Application No: 19/01740/HYBRID-3

Location: Land Adj To Promised Land Farm, Wendlebury Road, Chesterton

Local Lead Flood Authority

Officer's Name: Adam Littler

# **BAILEY JOHNSON HAYES SURFACE WATER DRAINAGE SCHEME & CALCULATIONS**

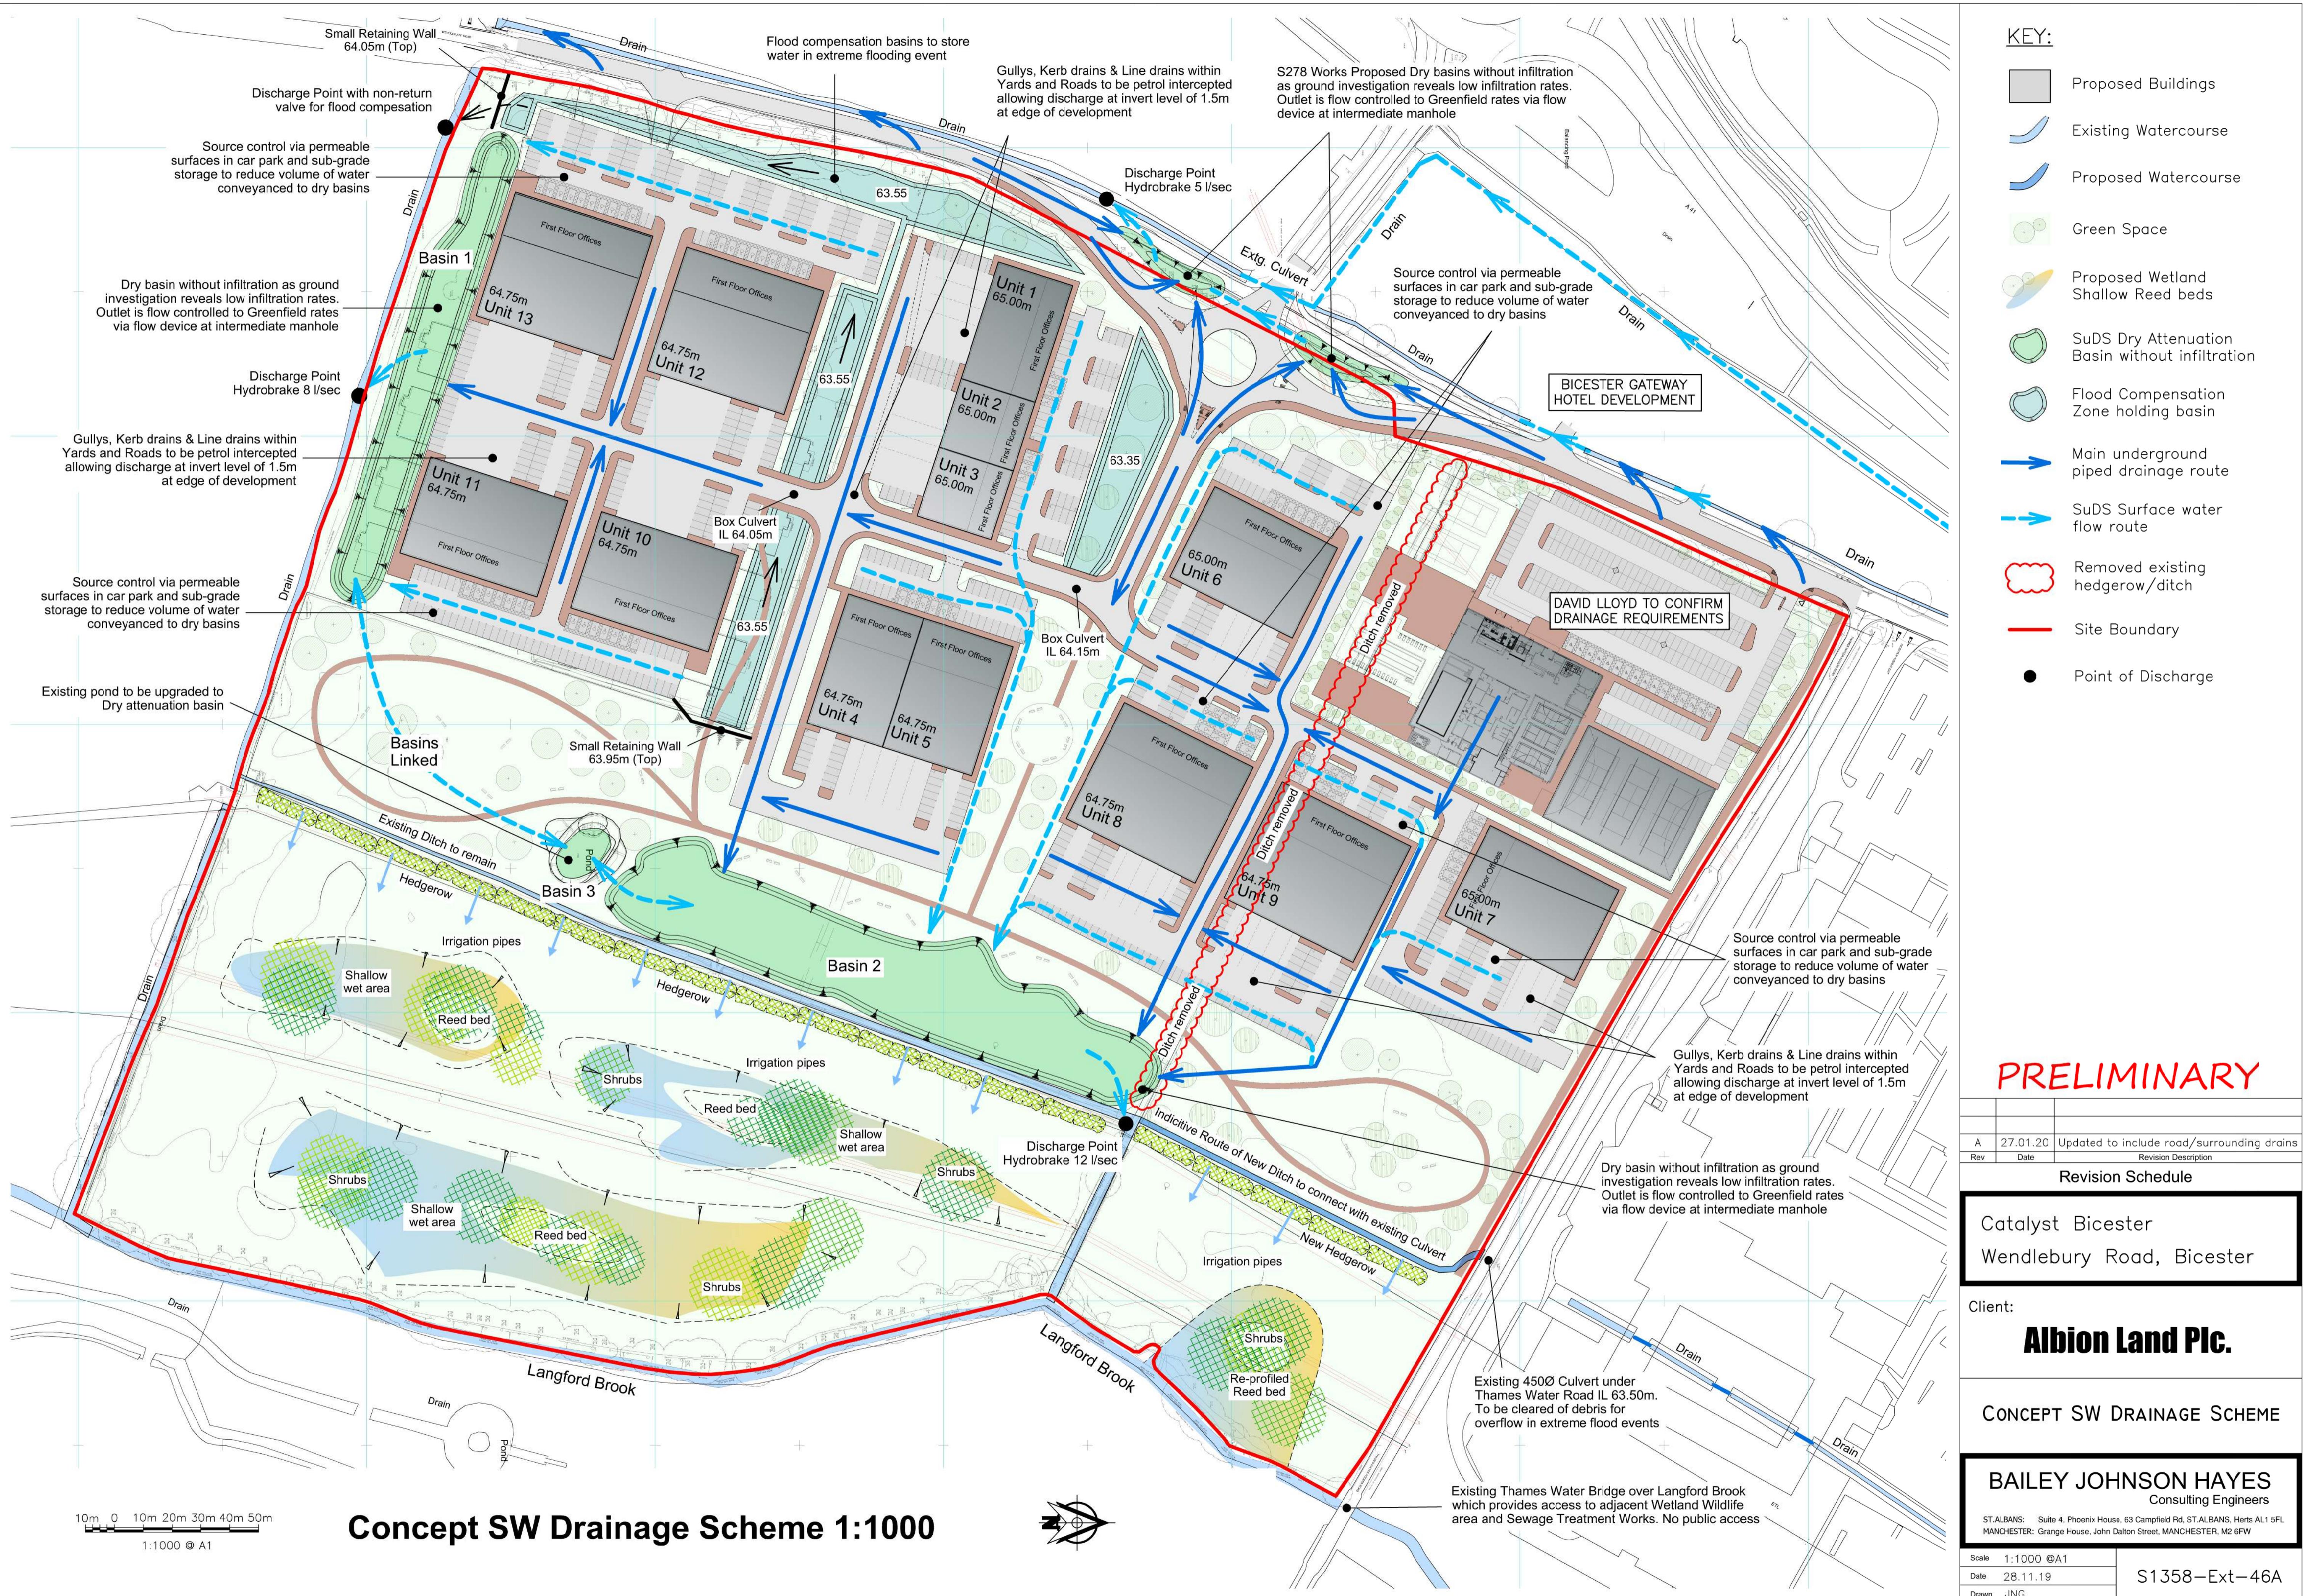
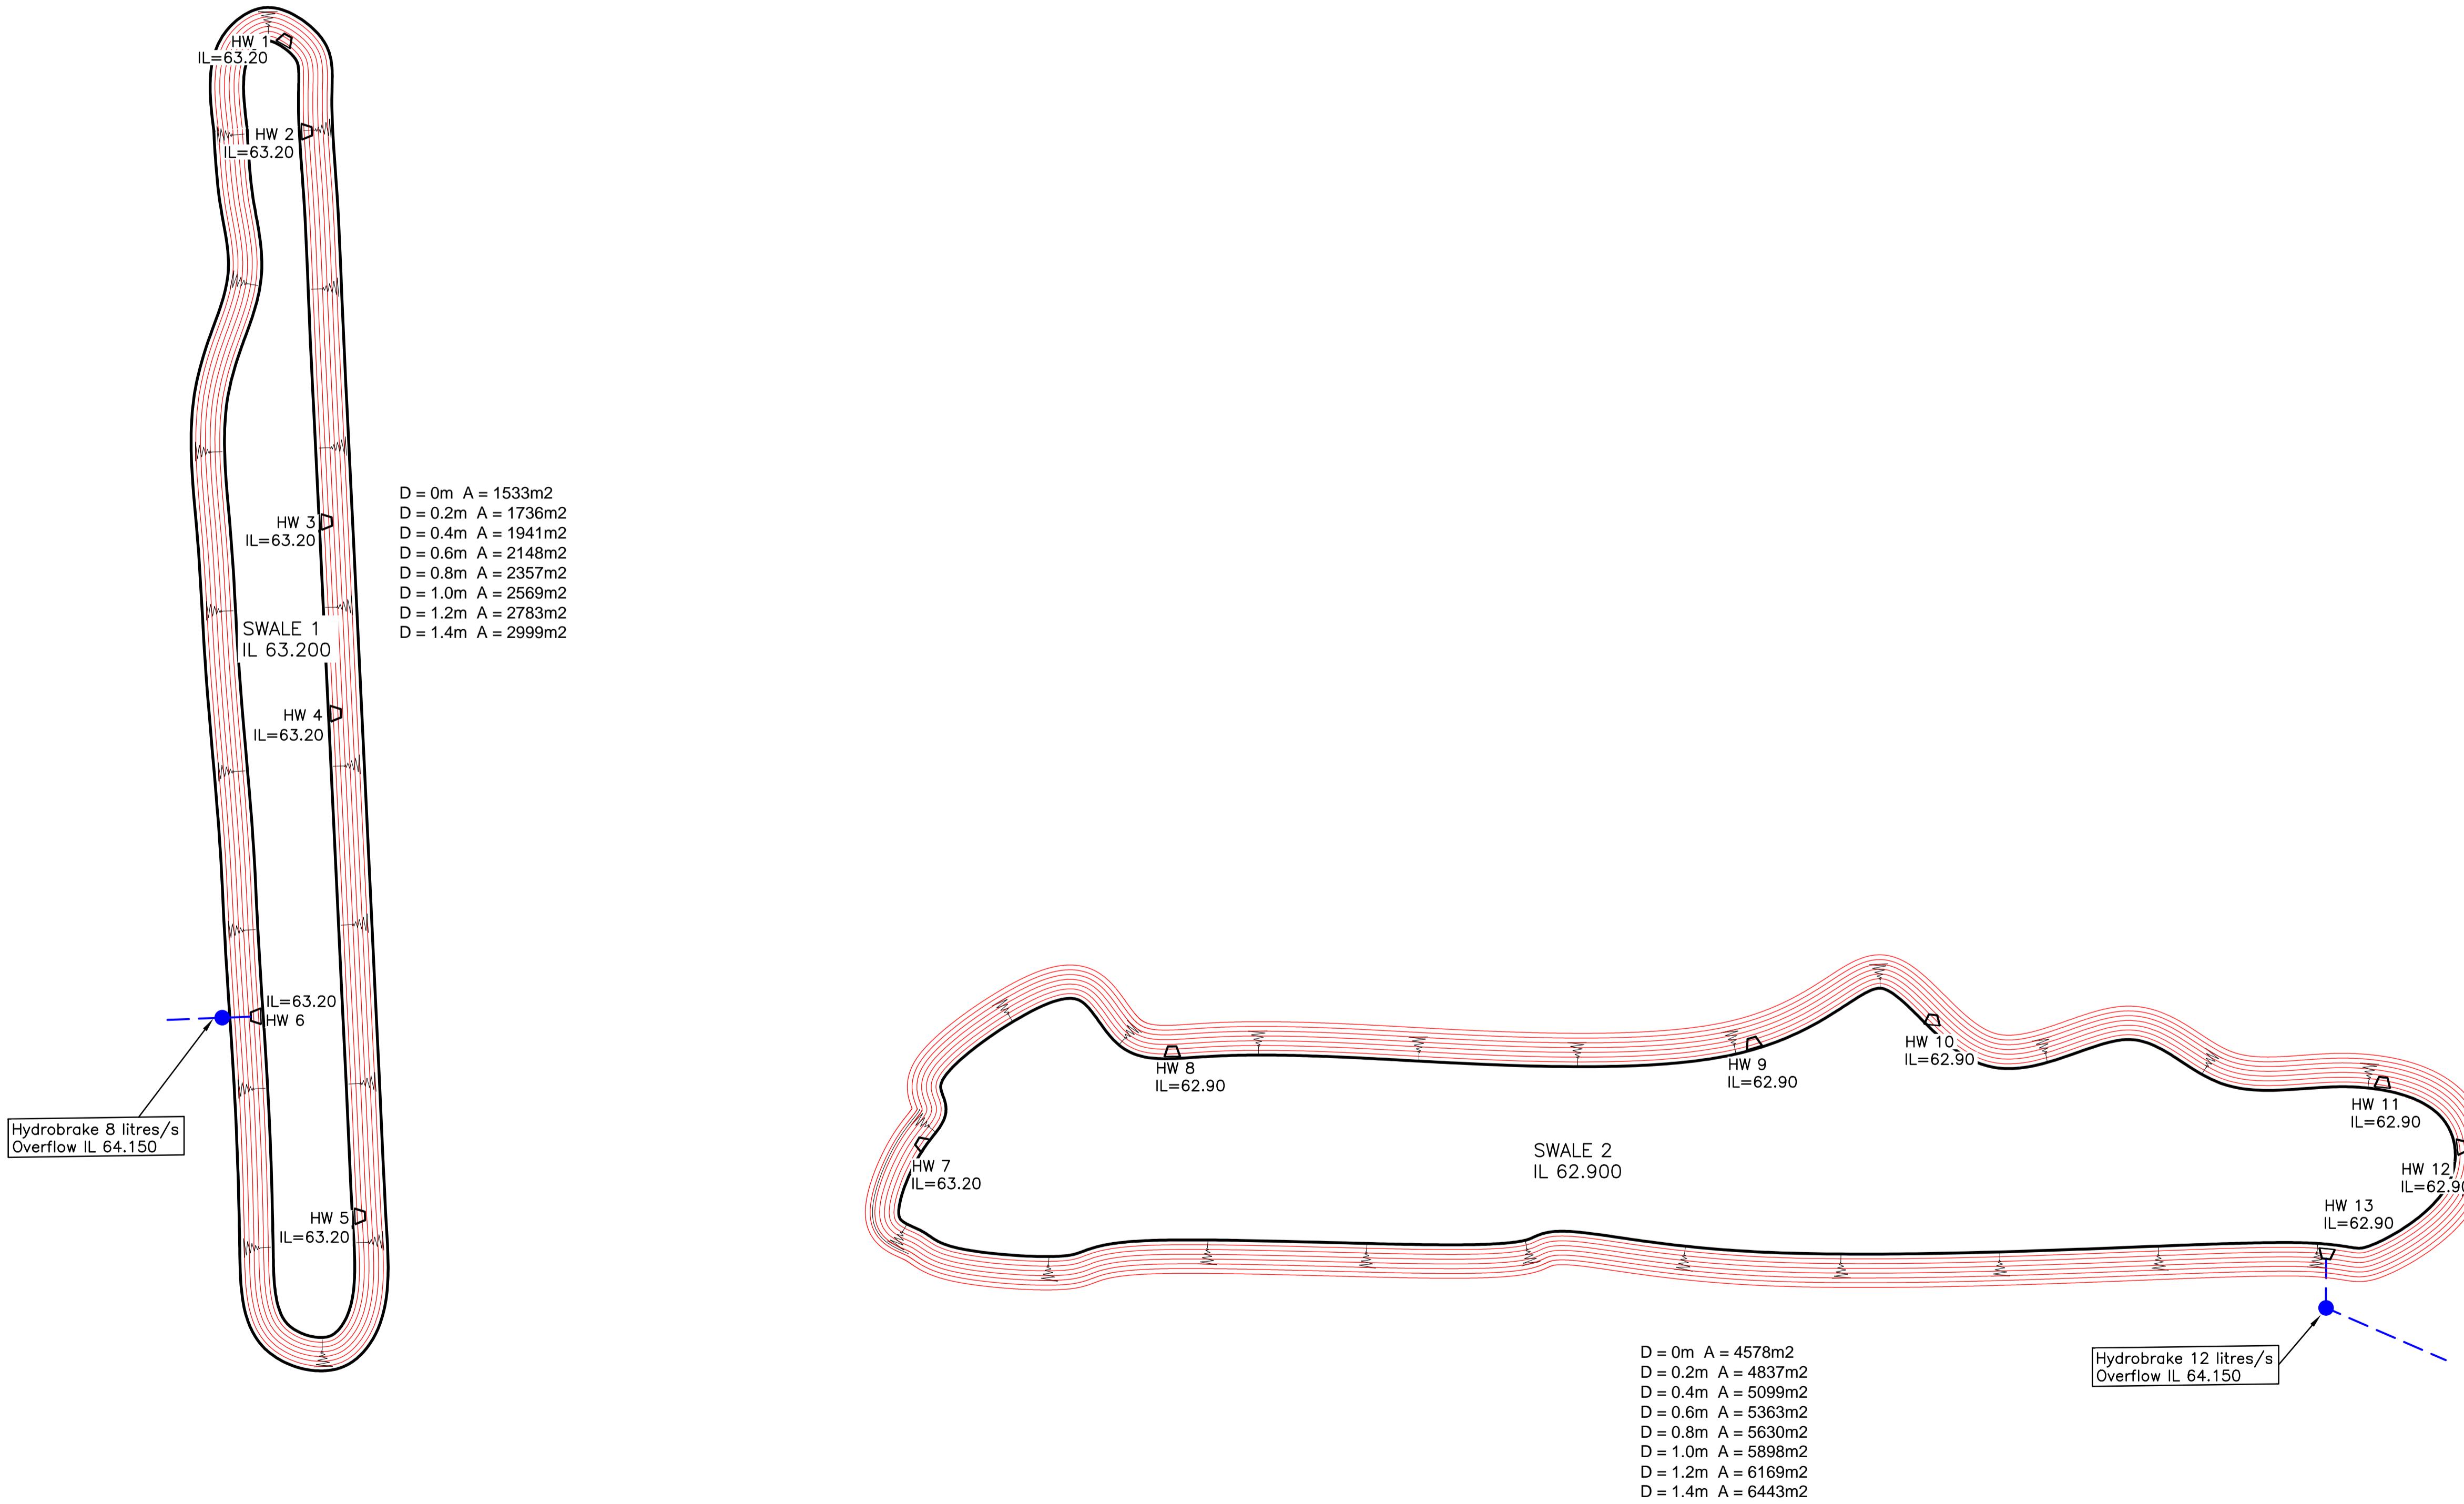
- Appendix J (PART 10 OF 11)
- Appendix K (PART 11 OF 11)
- MicroDrainage Half Drain Down Times are to be confirmed and ensure they conform to standards.

- Storage elements should be designed to empty sufficiently within 24 hours to be able to accommodate 80% of the 10% (1in10) storm runoff.
- Phasing will be agreed by parcel between the Applicant the LLFA and LPA as the site construction development plan evolves.
